**KIRKLEES METROPOLITAN COUNCIL
INVESTMENT & REGENERATION SERVICE**

**DELEGATED DECISION TO DETERMINE APPLICATIONS FOR LISTED
BUILDING CONSENT**

Reference No: 2021/65/90593/W

Site Address: 88, Handel Street, Golcar, Huddersfield, HD7 4AE

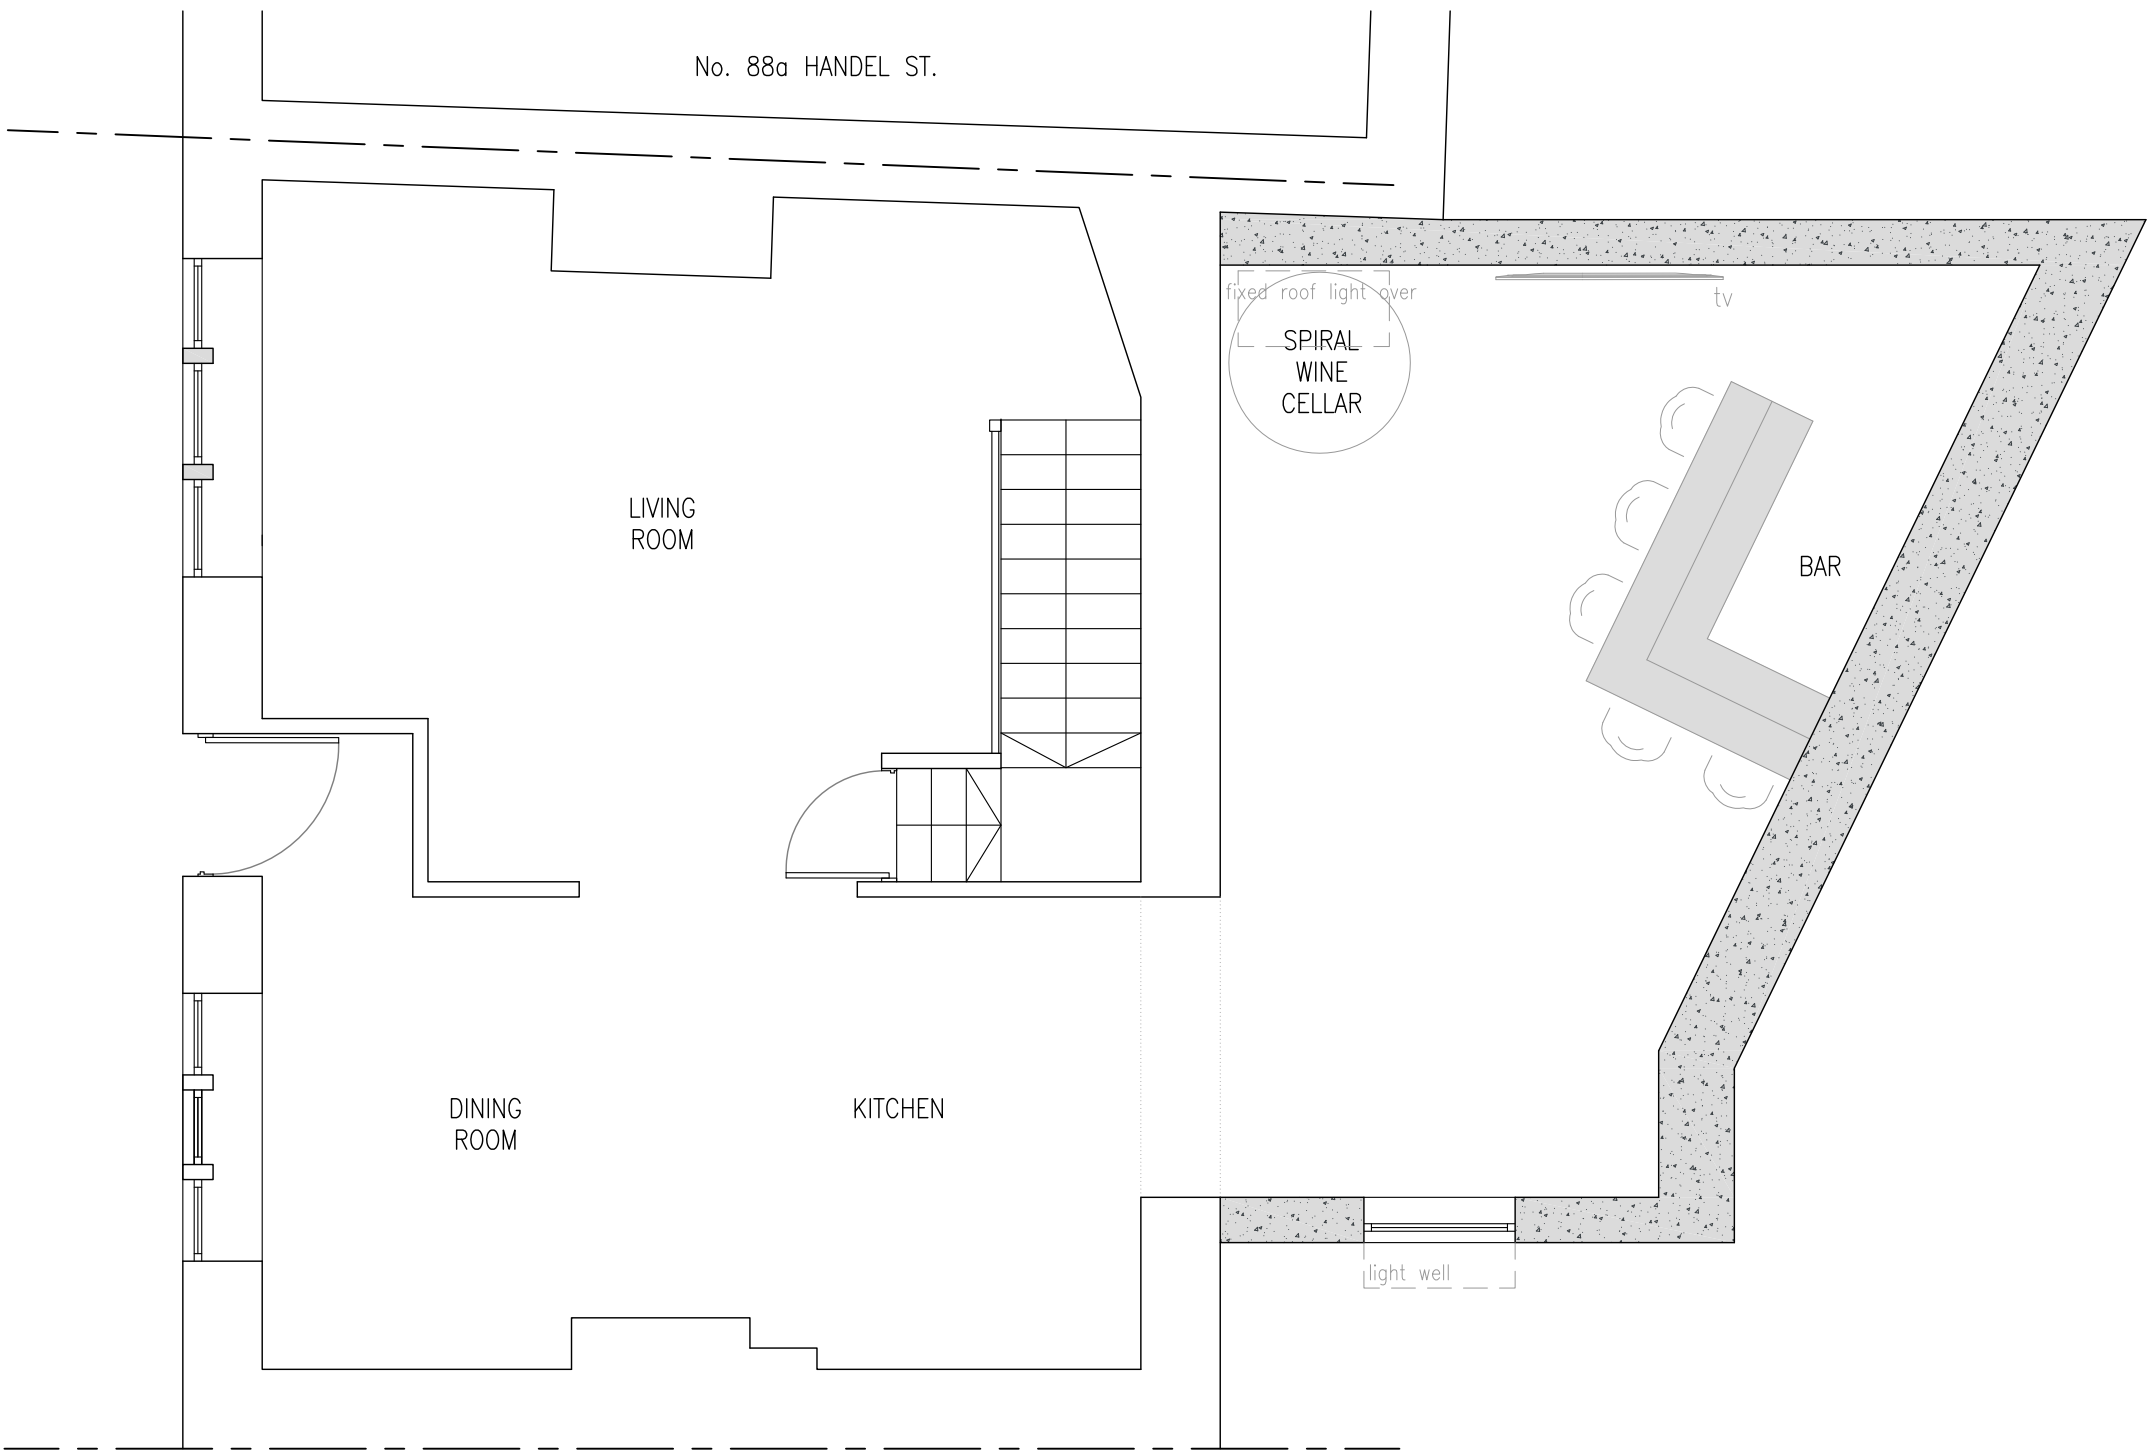
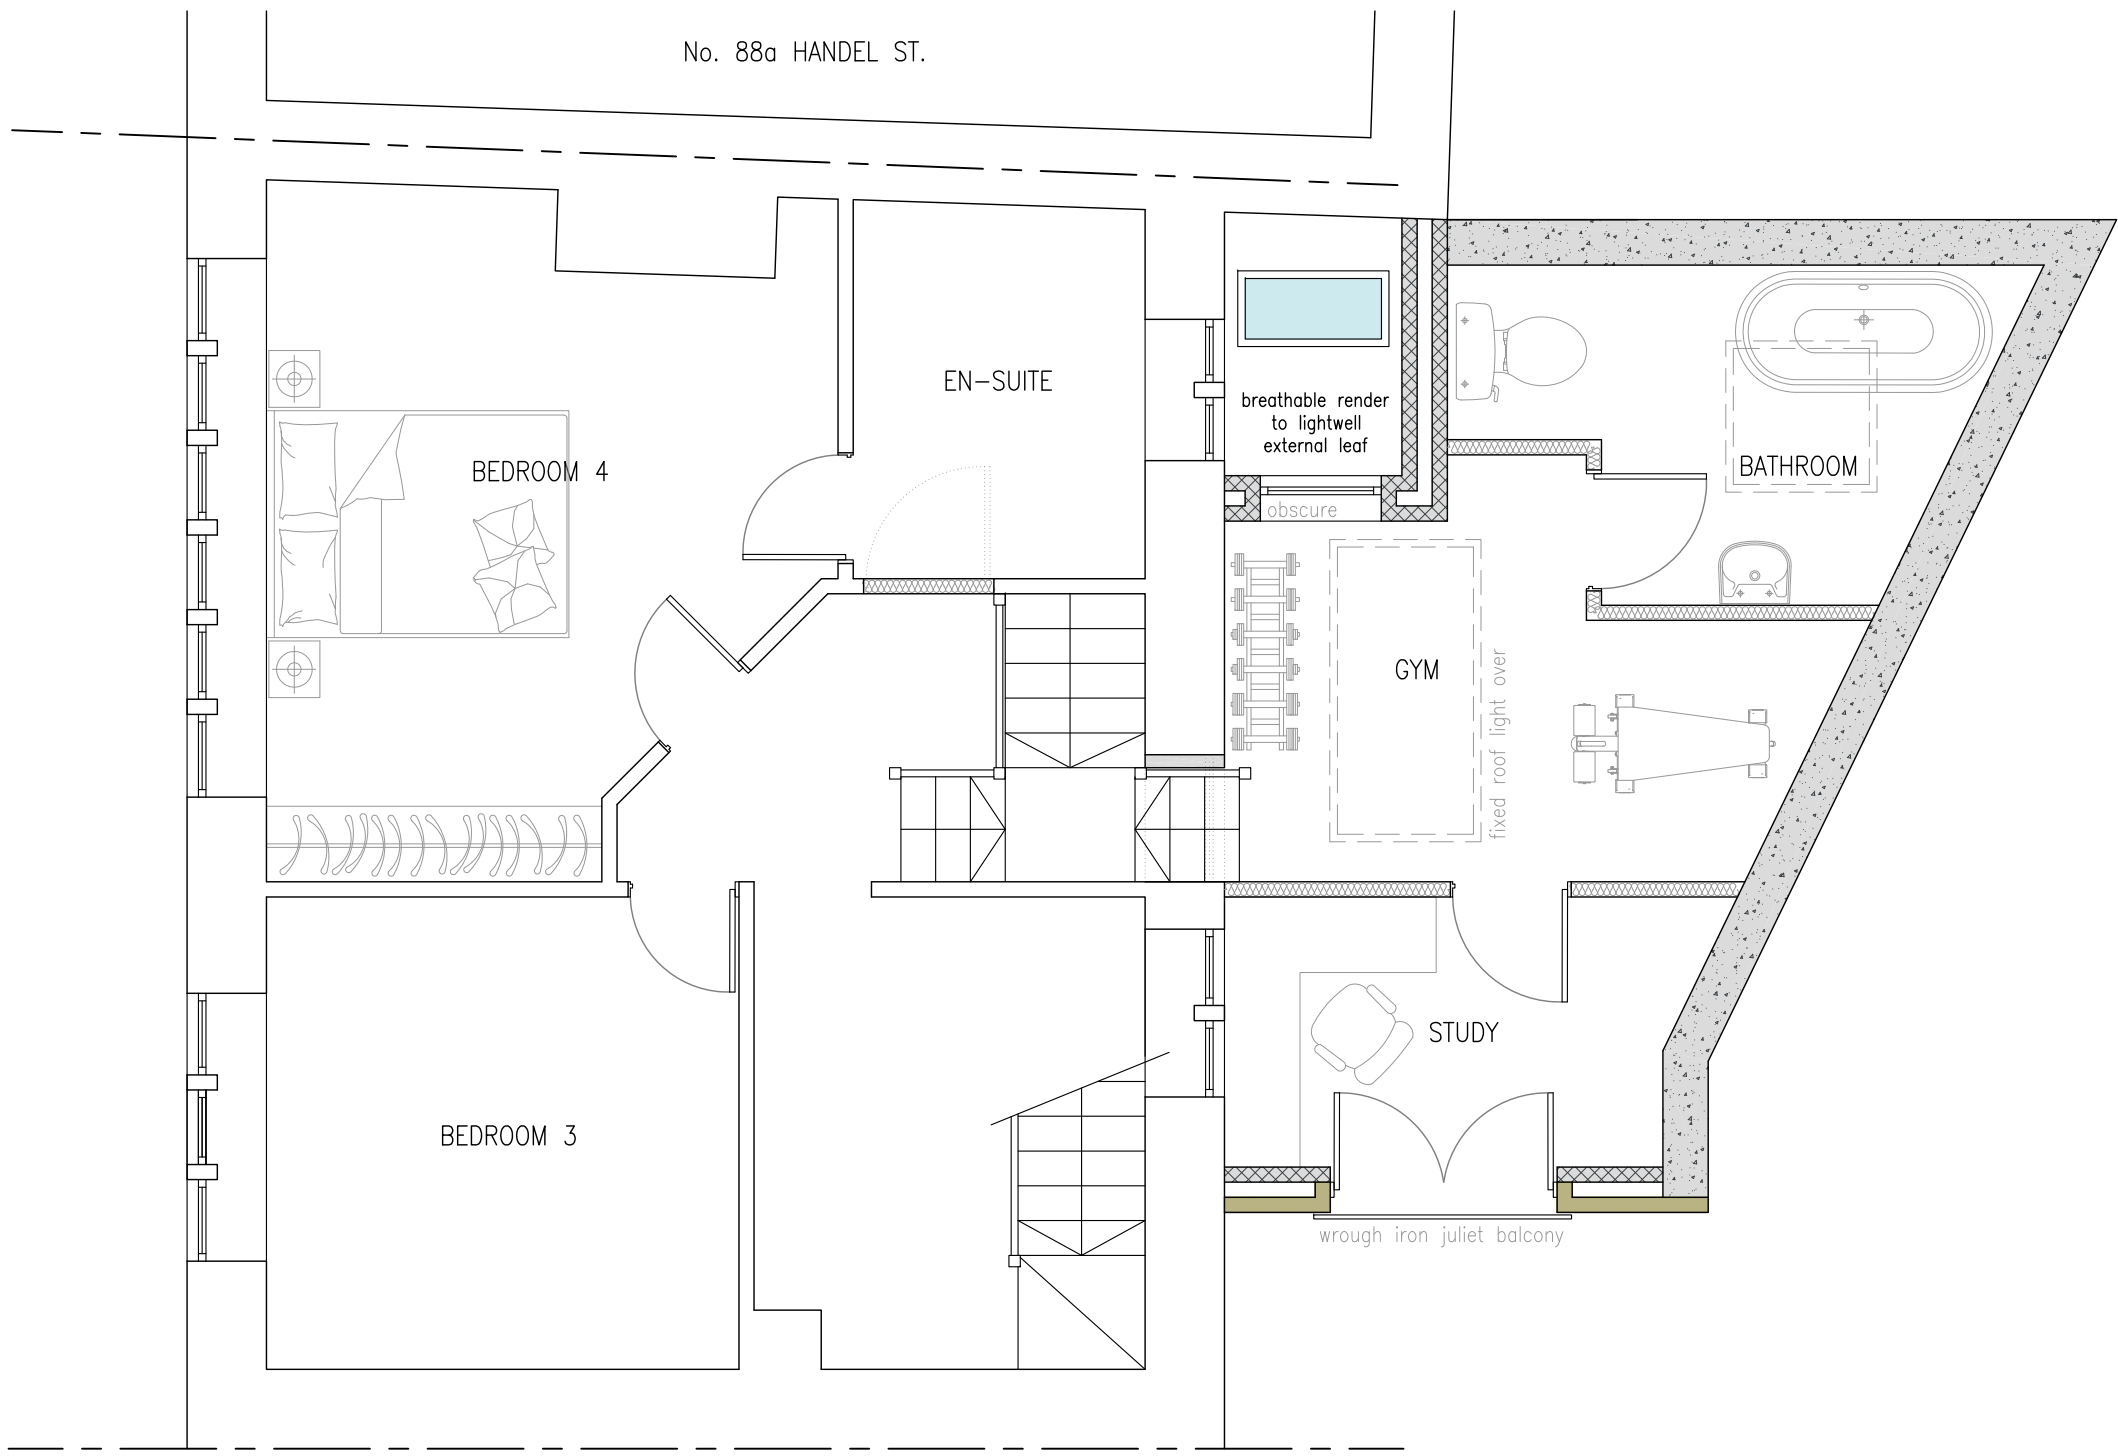
The case officer considered the application on review and sought amendments after the Conservation & Design Officer's consultation response

to have a parapet roof detail and wrought iron railings and to receive more in-depth detail on the ventilation for the lightwell for avoidance of condensation and damage to the Listed Buildings.

Two structural openings are proposed from the house into the new extension, one on the ground floor where no historic openings will be disturbed, and access on the first floor where a previously blocked up opening will be reinstated to create access into the extension; the relocation of a doorway proposed at first floor level to create en-suite was not of concern to the Conservation & Design Officer as it is likely to be a later partition.

An internal lightwell is proposed to provide borrowed light to the en-suite and gym and which is acceptable as the mullioned windows of the house is retained within this space. A low level roof ventilator adjacent to the roof light in matt black would provide ventilation to the void with dimensions of 300mm in diameter and flush mounted which was reviewed by the Conservation & Design Officer and found acceptable for reducing risk of condensation to the host dwelling.
